Subject: FW: FG/171/18/DOC - Yeomans Honda Discharge of Conditions

This is a complicated site due to historic flooding in close proximity (see attached photo). We even commissioned our own flood study report to try to find ways to resolve the flooding issues in this area. This development lies

Condition 3 relates to the surface water drainage on site and includes the words '*winter groundwater monitoring*' – whilst familiar with this and the necessity to determine highest levels, neither ourselves nor our civil engineer has come across a condition worded so onerously or counter-development in its detail;

Title **Drainage Layout**

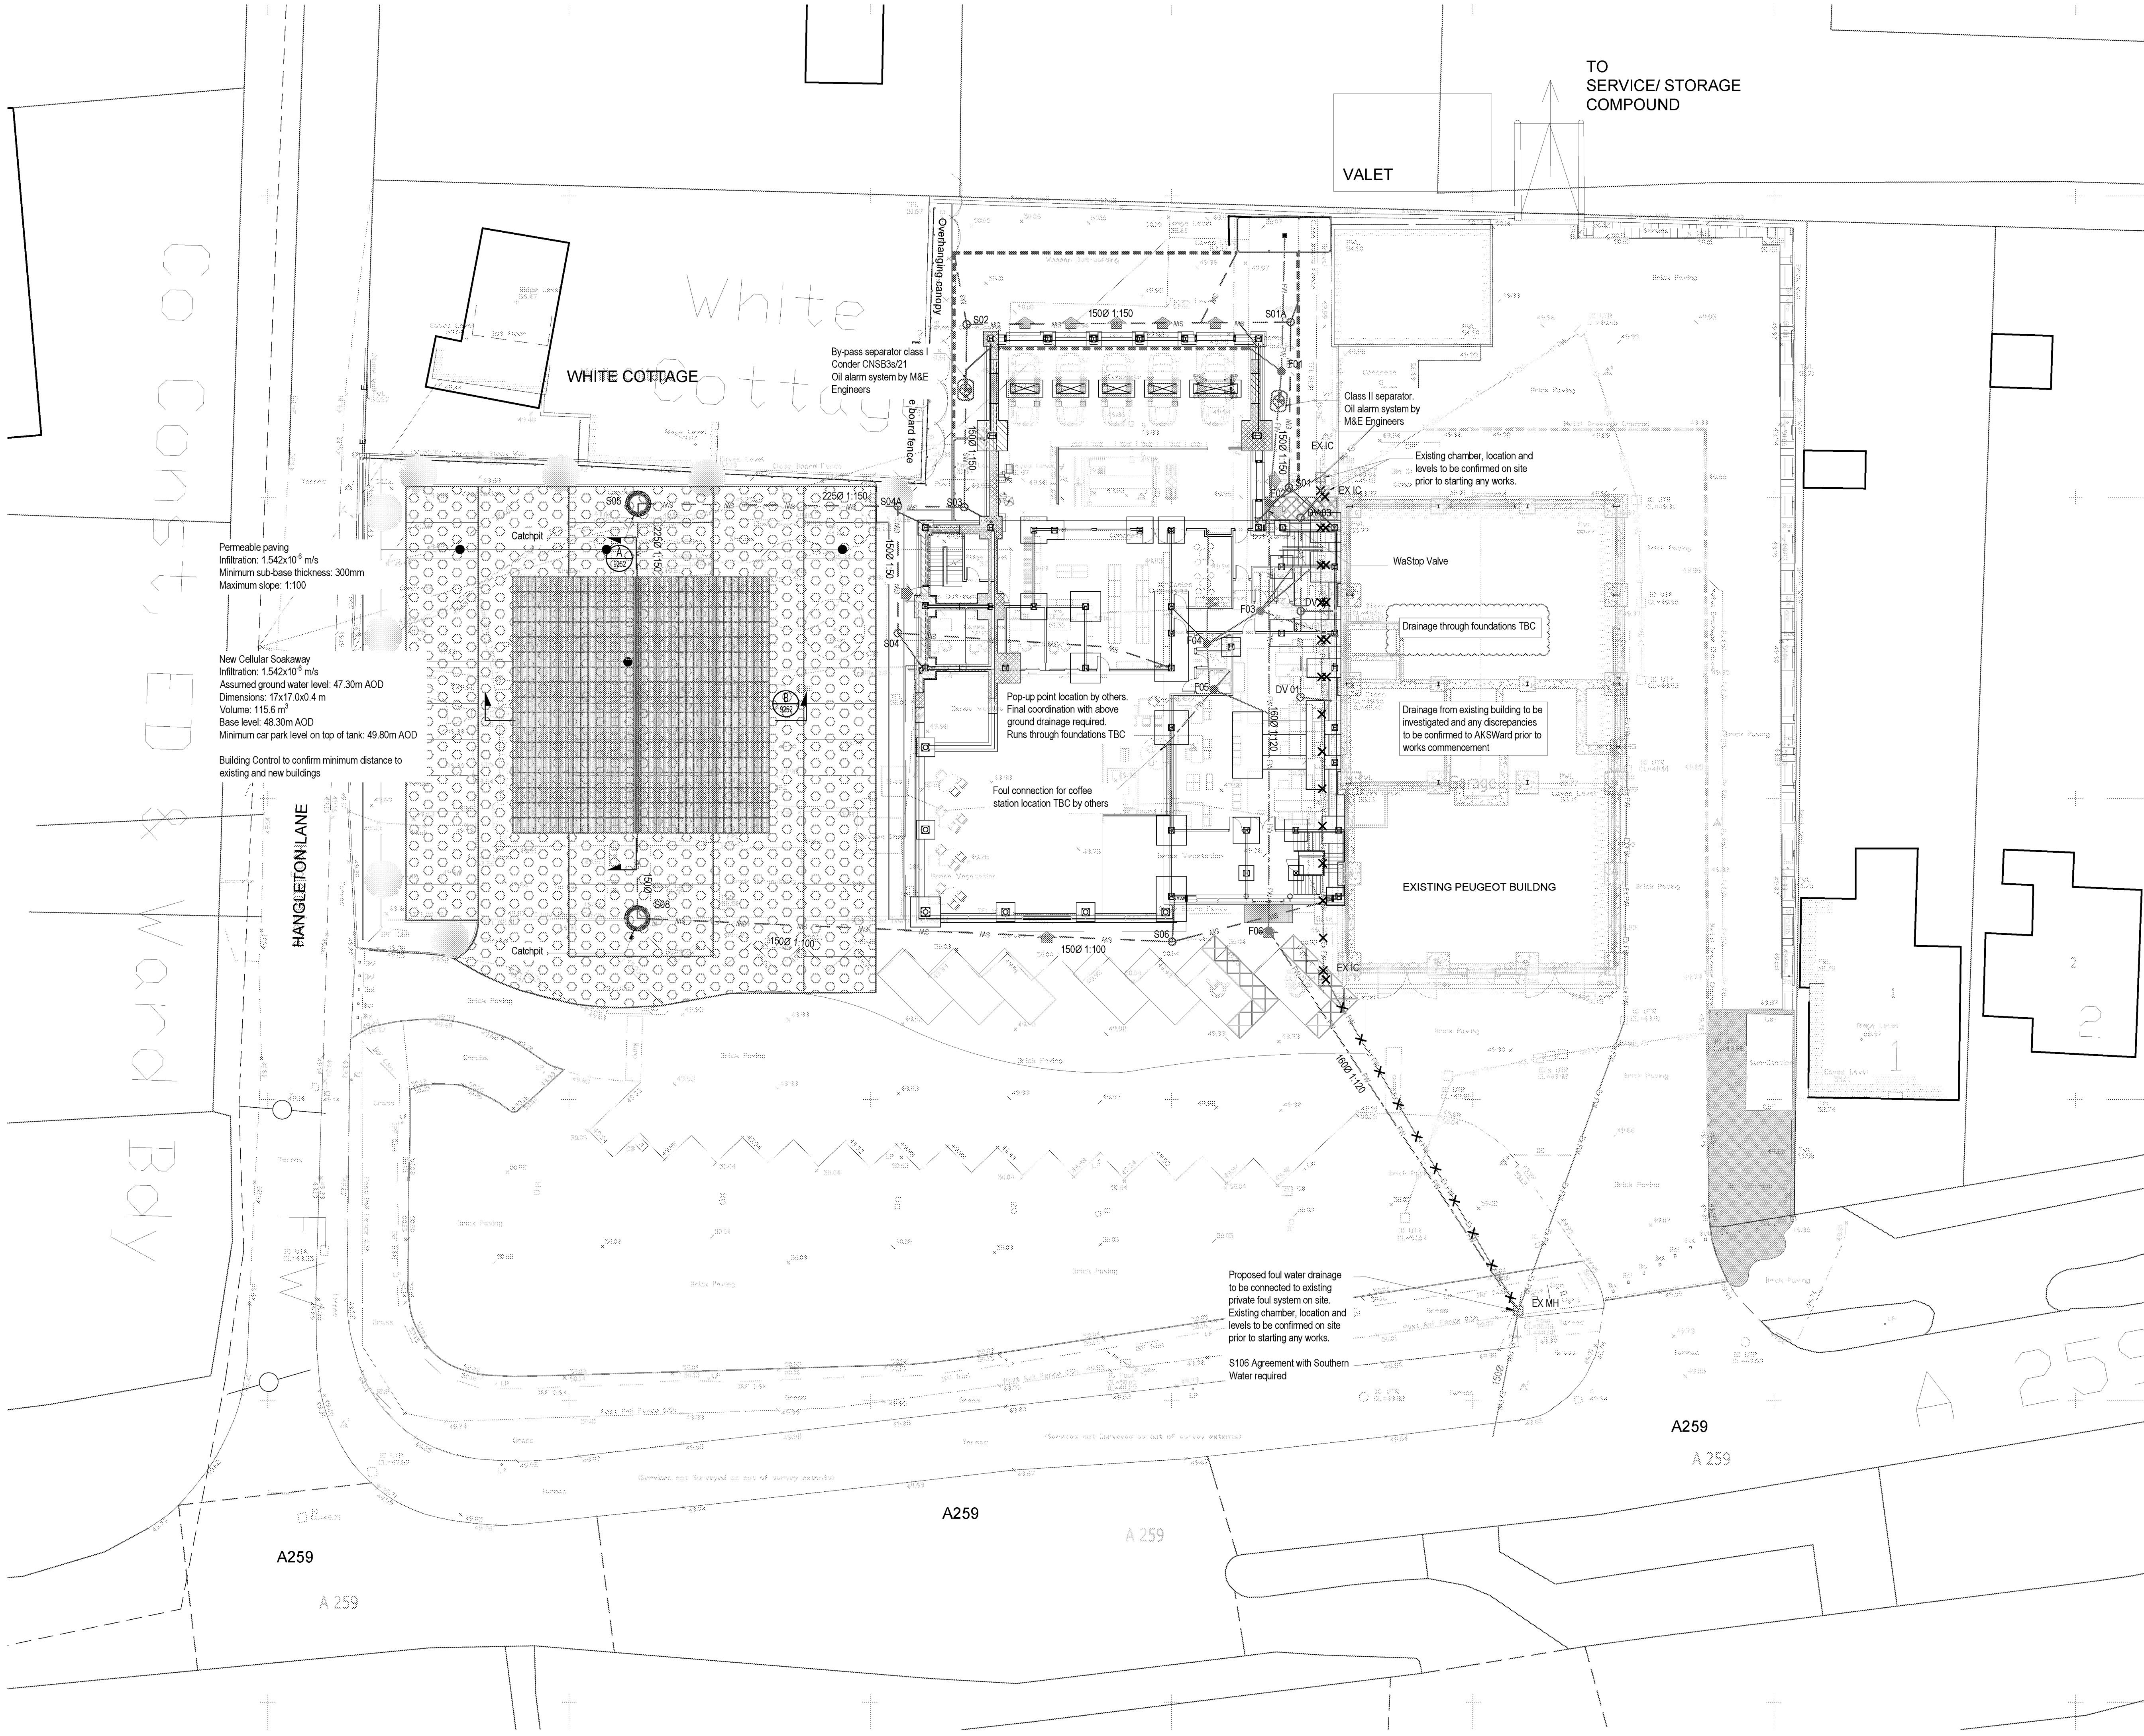
within one of the catchments identified as a source of flooding. It is even acknowledged within the drainage strategy submitted that currently water flows overground to Hangleton Lane during saturated conditions.

Our current infiltration testing, which does not include all of the winter months, has informed the drainage design that's principal has been accepted as part of the consent. The proposal includes the ability to manage *greater* depths of groundwater than those tested; indeed our proposed tank needs to be a minimum of 1.0m above the level of the water table and it is currently at **1.5m above** - it would therefore require a *significant amount of water to increase this level to potentially cause a problem* – the information for which would all become available through on-going monitoring of the ground water once construction has commenced. Within Arun District it is common for ground water levels to fluctuate by over 2m.

*"The infiltration system has been designed in accordance with current guidance and is located **1m above** the highest recorded ground water level on the site in accordance with current guidance. Further ground water monitoring can be carried out if there is a specific risk of ground water movement in this area, but this should not prevent the development from proceeding. The infiltration tank will not be installed until the ground water monitoring is complete. Should the ground water monitoring confirm a higher water level then the surface water drainage design will be adjusted and submitted for approval prior to any surface water drainage works."*

APPENDIX C – DELIVERY VEHICLE (LARGEST ANTICIPATED) TURNING HEAD PLAN

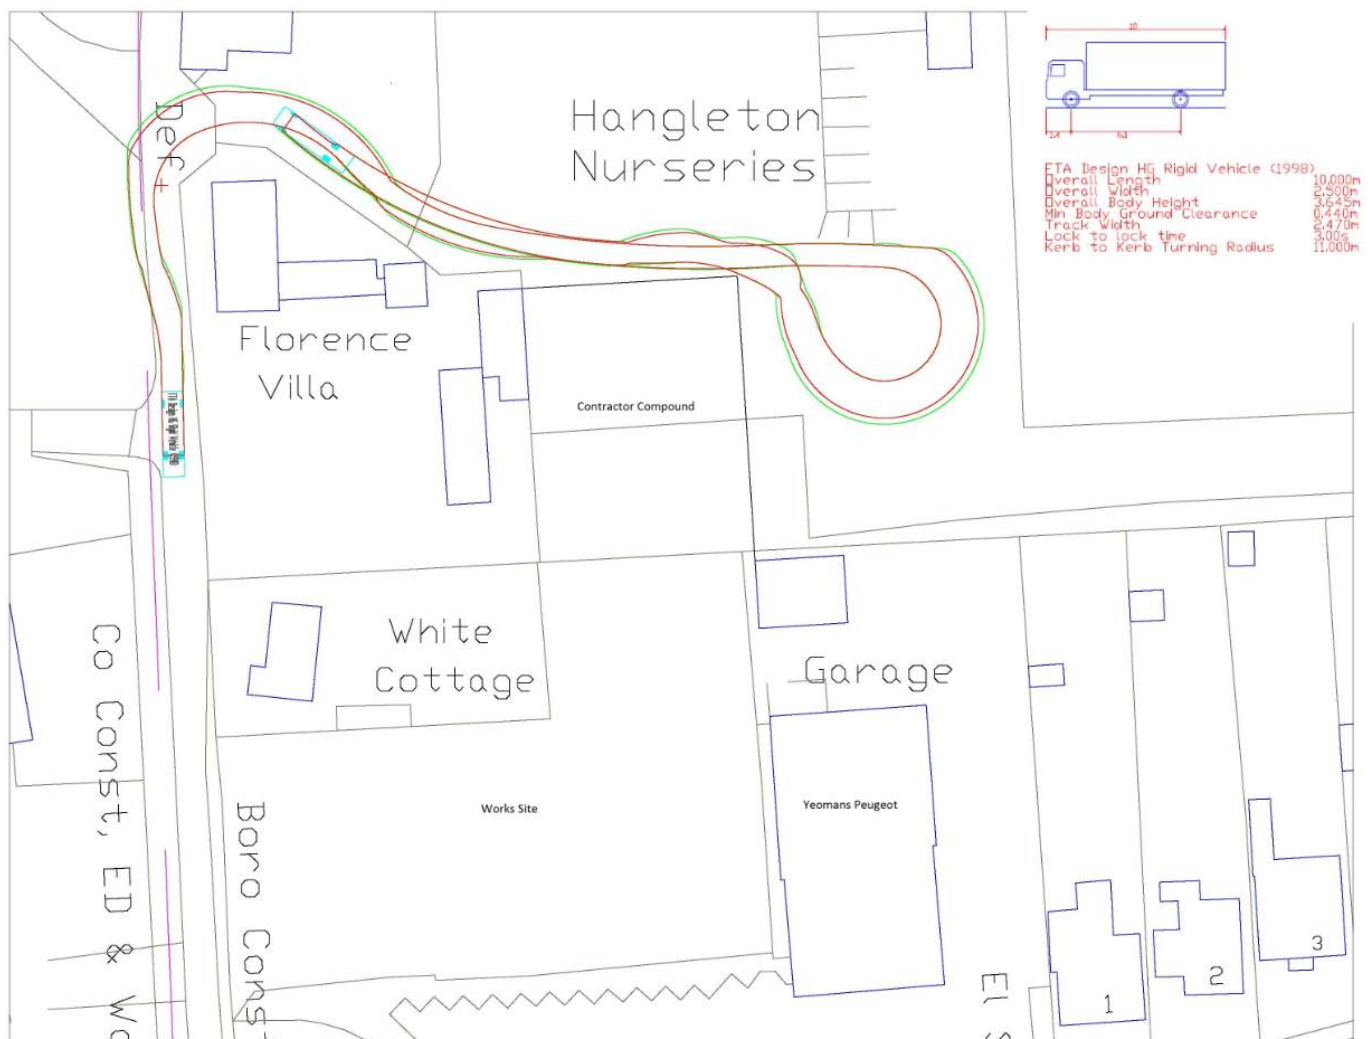
- *Maximum size of delivery vehicles. The CMP states no articulated vehicles will be used however rigid vehicles can have a limited turning circle. We have reviewed this with the main contractor and determine a maximum delivery lorry size at 2.5m wide x 10m long.*

- *Swept paths for maximum vehicle size of; the access and of turning within the site. Swept paths should be shown on the CMP with all other obstructions ie parking also shown. The turning head 'banjo' of this largest vehicle is illustrated on the attached updated CMP.*

APPENDIX D – CRANAGE

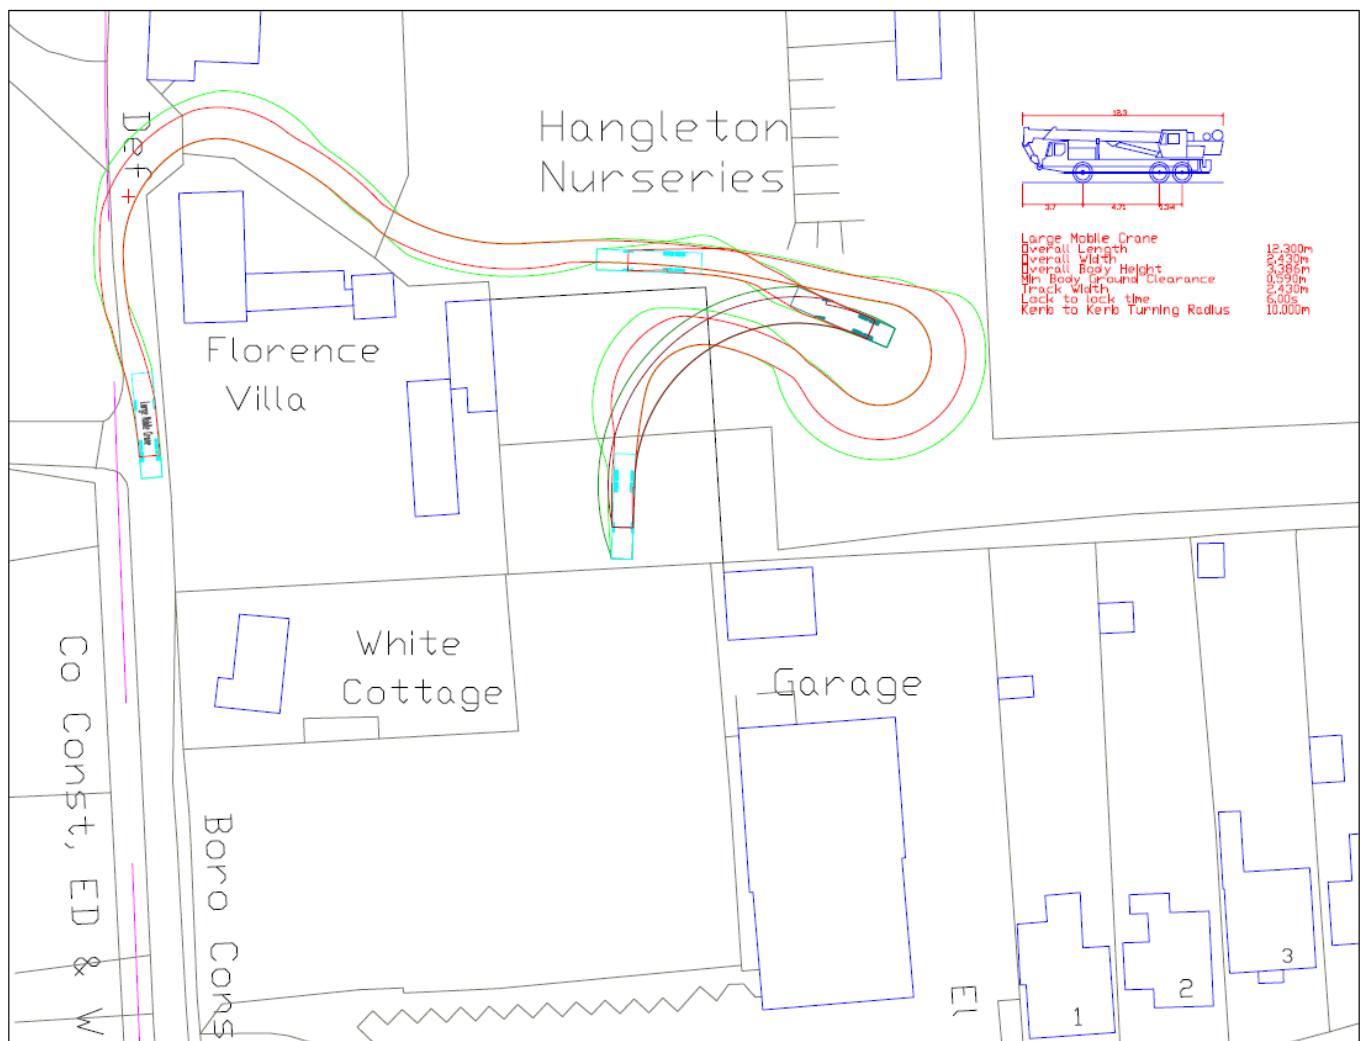
- *Details of any extra-large plant expected ie Cranes. The main contractor has highlighted a maximum 25 tonne crane for these works. The turning of this vehicle can be made on site and is illustrated on the attached updated CMP. We expect this to be the largest piece of plant to be used here. All large plant turning within the site will have a vehicle marshalling 'banksman' coordinating movements.*
